Zoning Division
Marge Schmuckal
Zoning Administrator

June 25, 1999

RE: Hampton Street - 339-C-7 & 8 - R-3 zone

Plan drawn by Alfred J. Waxler showing placement of manufactured home on property (tax map lot # 339-C-007-001). Home shown on plan Plan drawn to scale. 1" = 10feet.

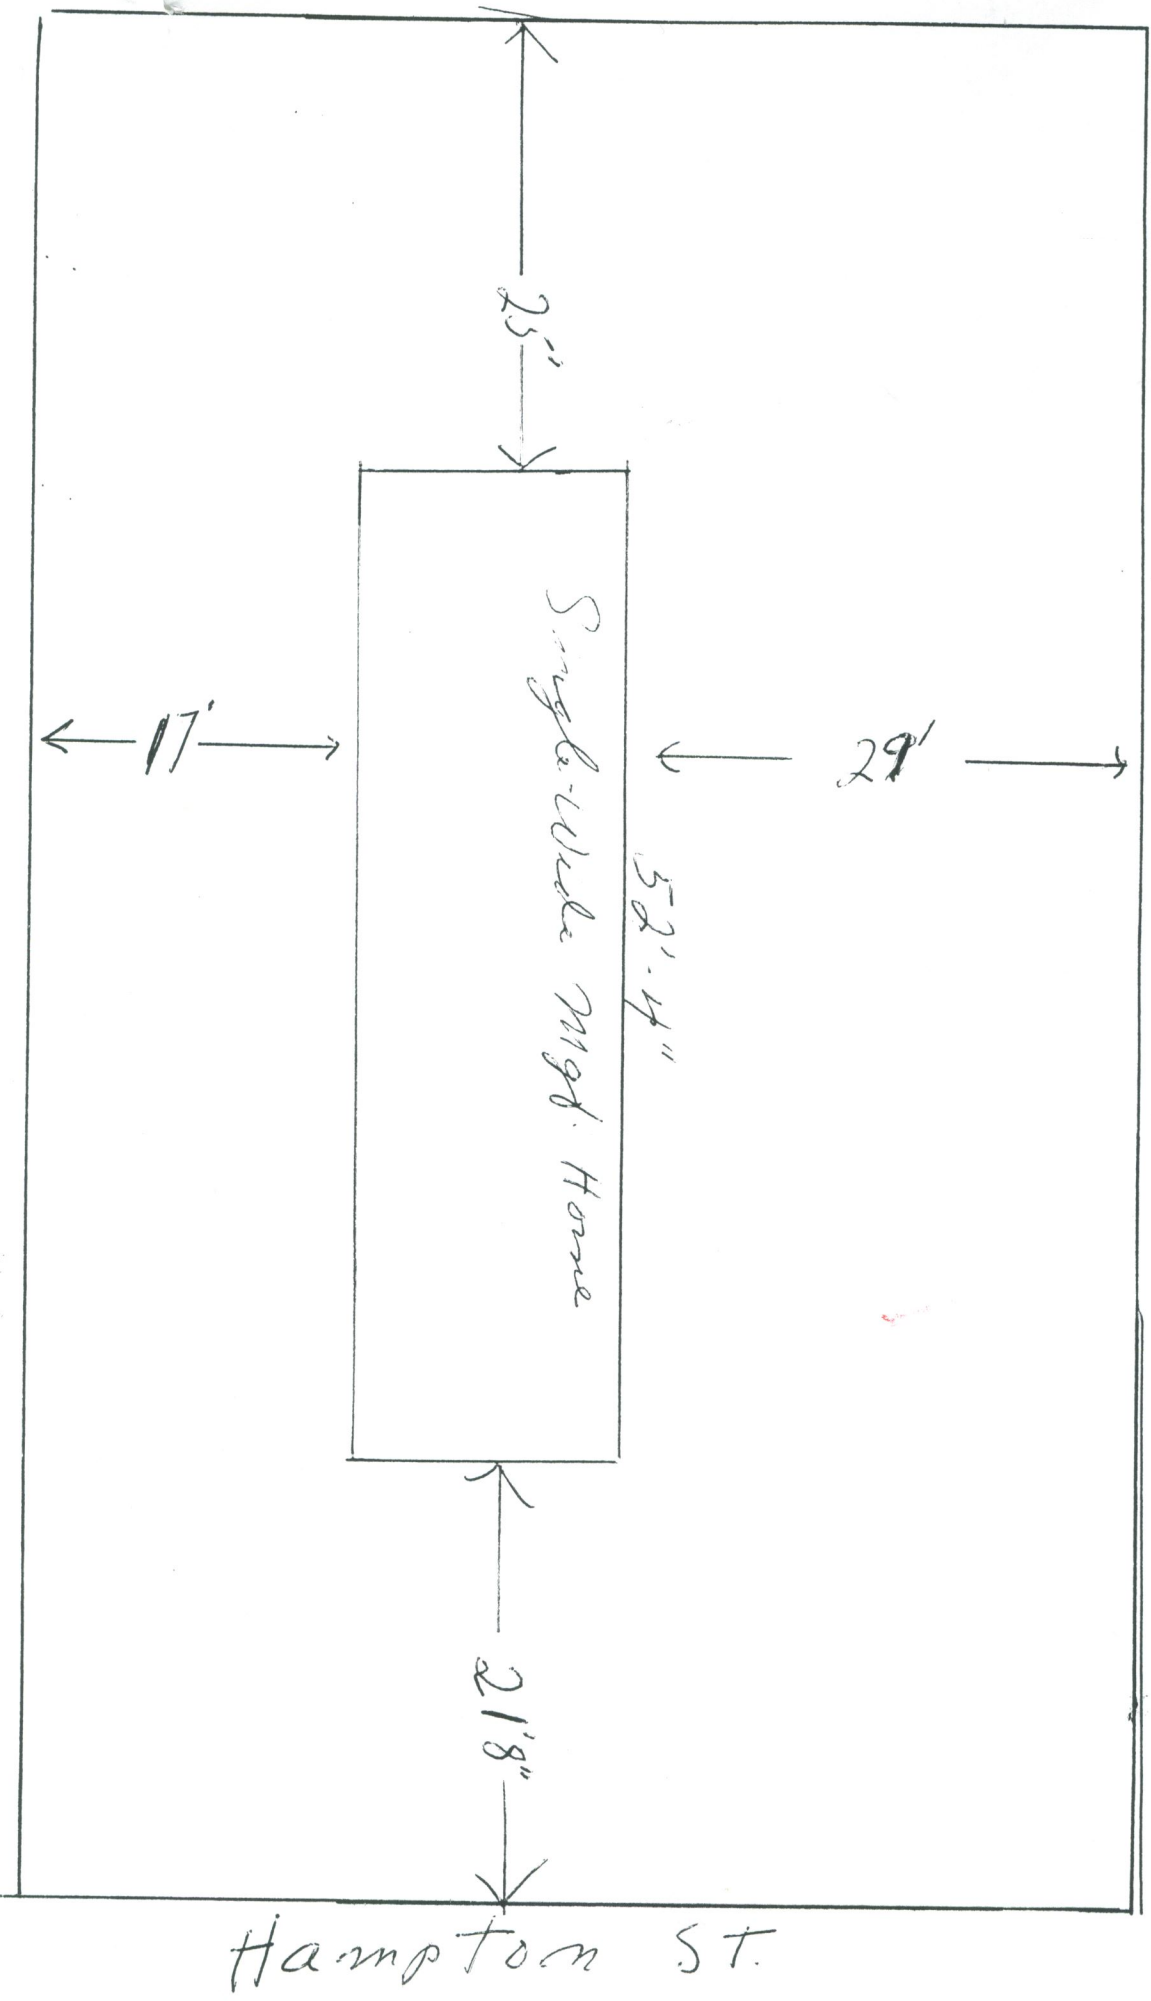
Please note that I have not done any extensive review of your plans, however several items should be address with your complete submittal. The current lot size is under the required 6,500 square feet minimum lot size. You would need to submit documentation showing that this lot would meet the all the requirements of a lot of record. You must show me that this lot has been held under separate and distinct ownership form any adjoining lot since June 5, 1957. I have enclosed a copy of this section of the zoning ordinance. (Sec. 14-433)

There is not enough information to determine your compliance with street requirements. If Hampton Street is unimproved or improved but unpaved, there are minimum requirements for street improvements that you would need to meet prior to completion of this building. I have enclosed Section 14-403 which outlines these requirements. The Public Works Department would be able to give all the technical standards to build this street.

It appears that this lot is not on public sewer. If you do not fall under the requirements of the Public Works Departments guidelines for a sewer hook-up, you would need to submit a current soil analysis with a current HHE200 form signed by the system's designer. The letter you submitted dated February 19, 1957 would not be sufficient.
